**WEST SUSSEX COUNTY COUNCIL
STRATEGIC PLANNING CONSULTATION**

SUBJECT: FP/90/13 - Phase 5: additional 7 dwellings & amendments to a further 33 dwellings following reserved matters approval ref. FP/128/09 in accordance with outline permission FP/92/04 - This application affects a Public Right of Way.

**Site 6 - Phase 5, Land North of Felpham, North Road, Felpham, Bognor Regis,
West Sussex**

Drawing Title:
PHASE 5.A RE-PLAN

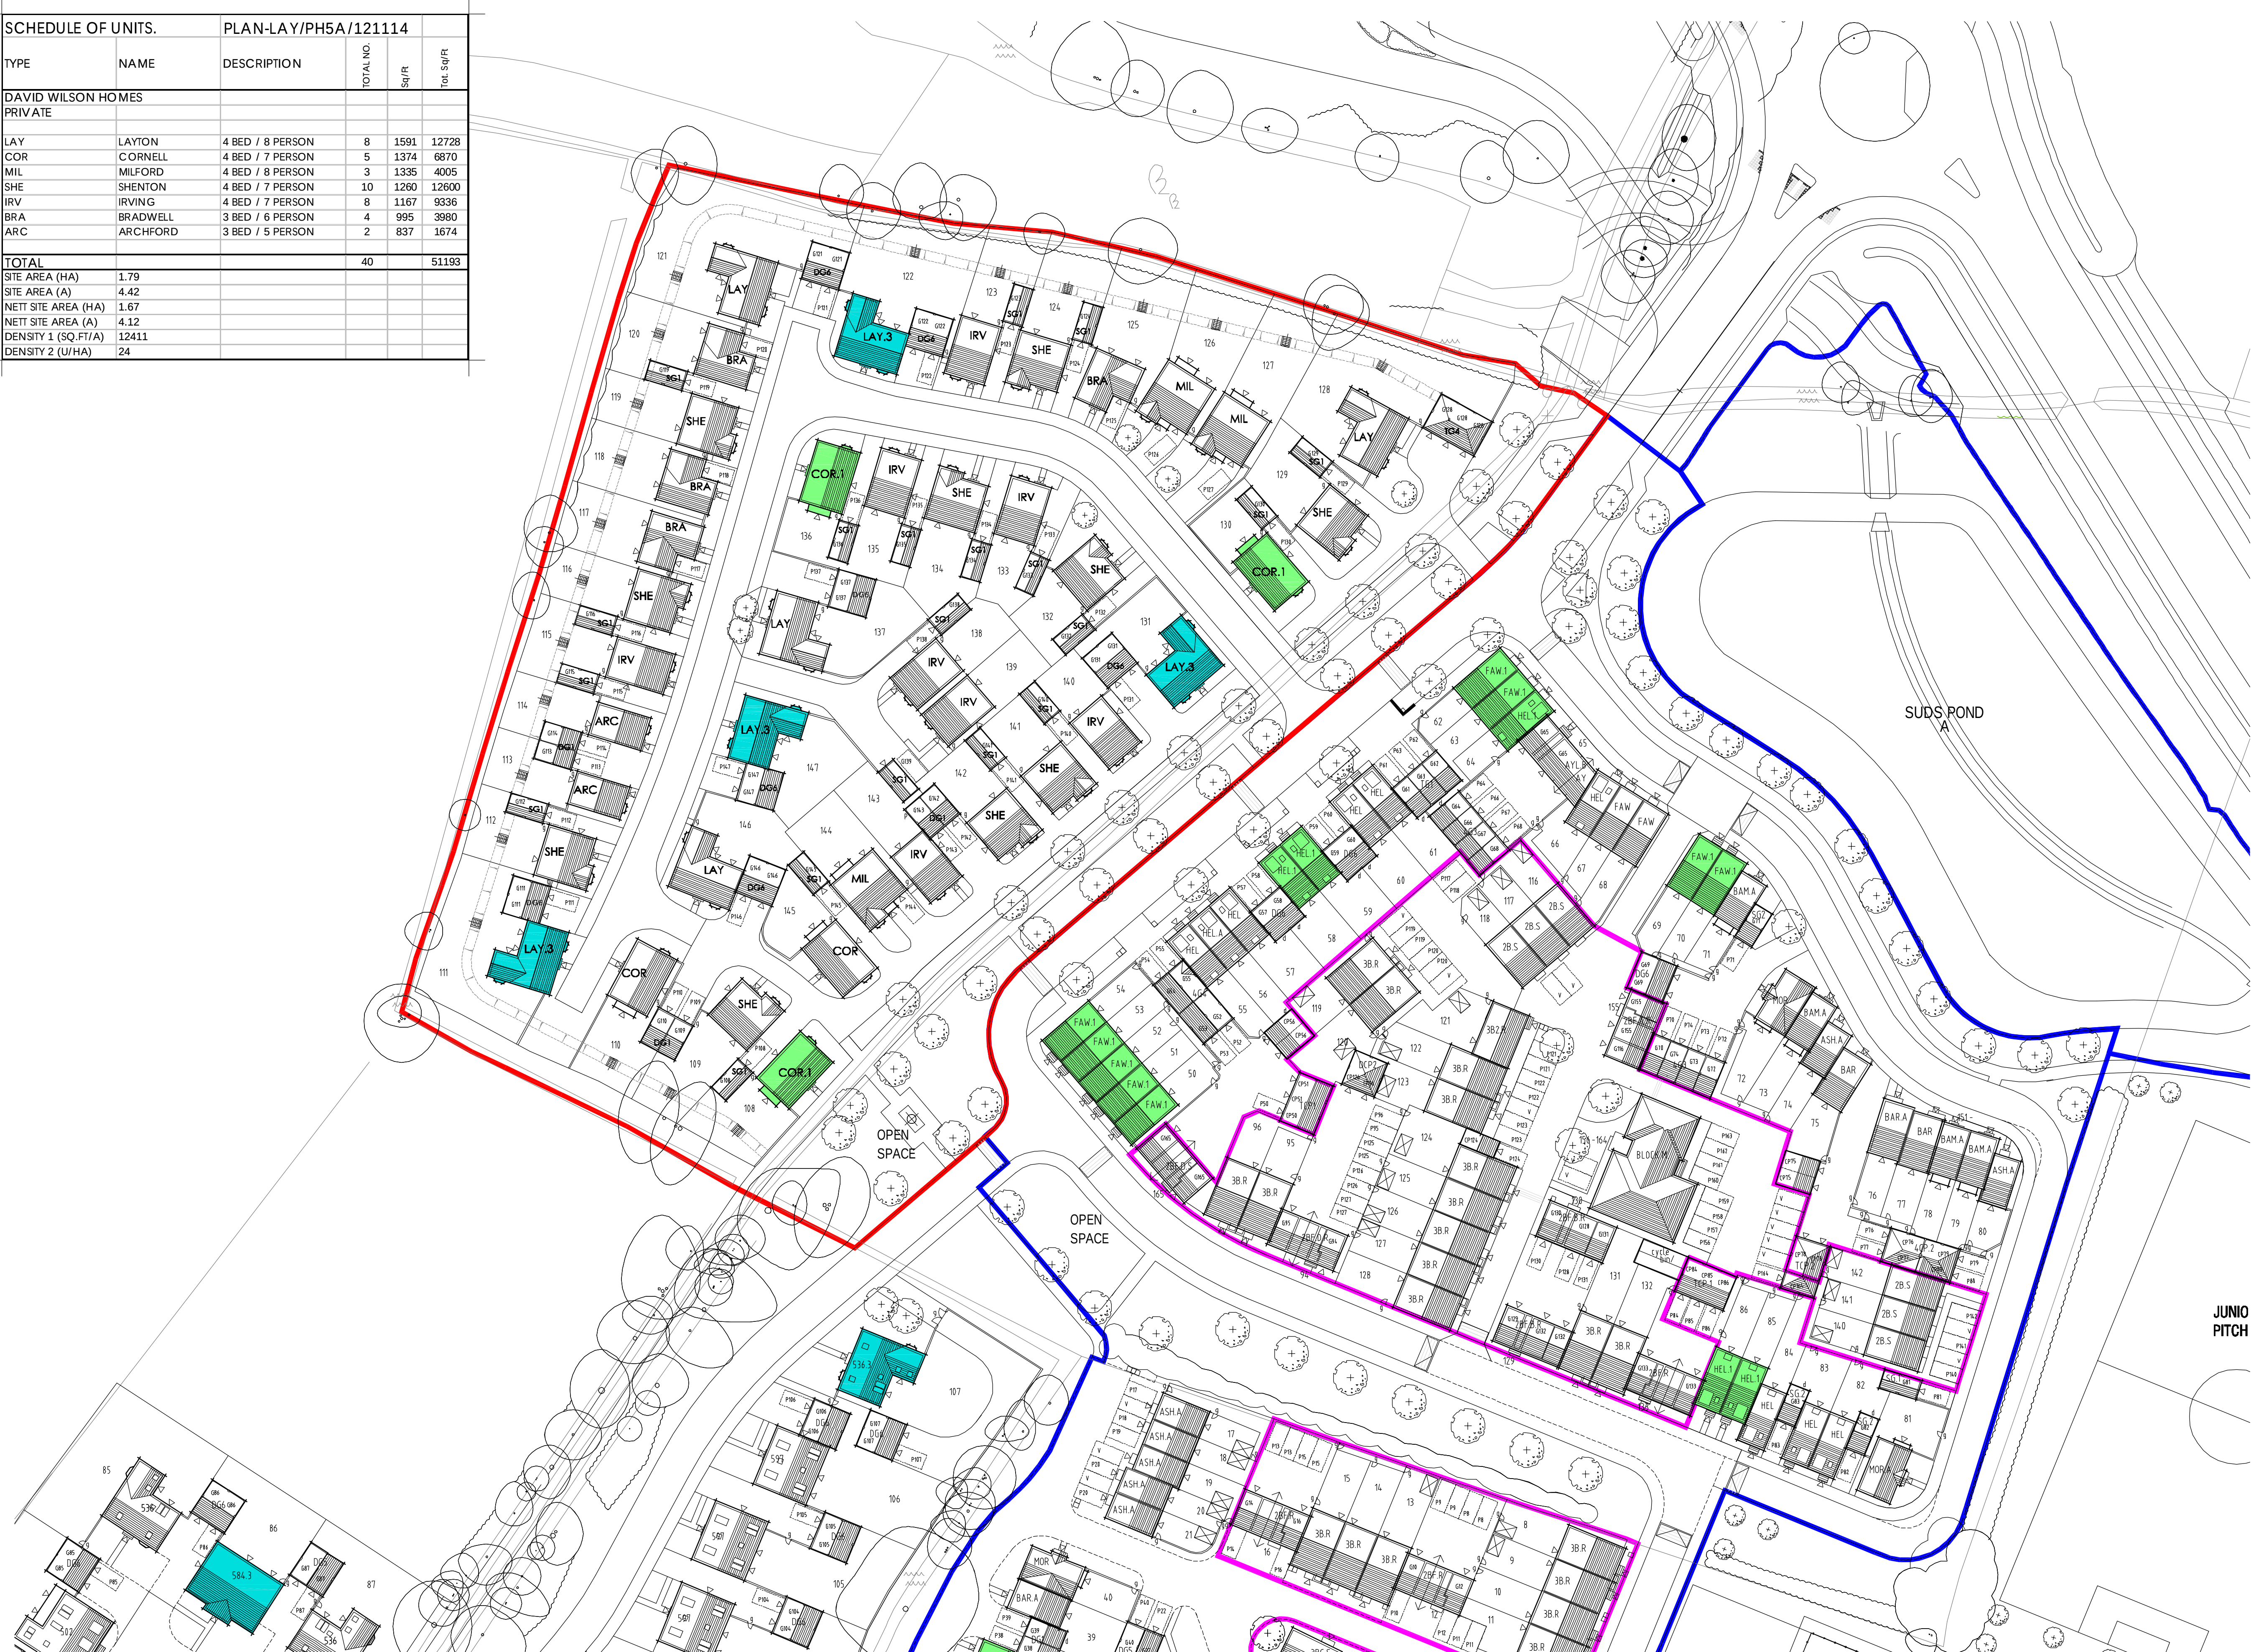
The proposed parking provision is significantly lower than the estimated anticipated demand (WSCC Parking Demand Calculator) which would be for 69 unallocated spaces. It is accepted that 45 car parking spaces have been approved previously. However, given the additional dwellings proposed and the changes to the housing mix, additional parking spaces/areas should be provided. It is my understanding that a condition has been attached to an earlier application for this development which stipulates an average number of parking spaces per dwelling, however I can not find any evidence of the condition at this time. Please request that the applicant provides a plan showing parking availability per dwelling. It may be that those dwellings with garages also have hardstandings which have previously been excluded from the provision.

I have yet to receive any information from our Public Rights of Way Officer. The submitted plans do not appear to show any changes to the road layout and the changes to the housing layout does not seem to have an impact on the Footpath (154) I therefore do not expect any concerns will be raised. However, the developer will need to ensure the footpath remains open and safe to use during the construction period.
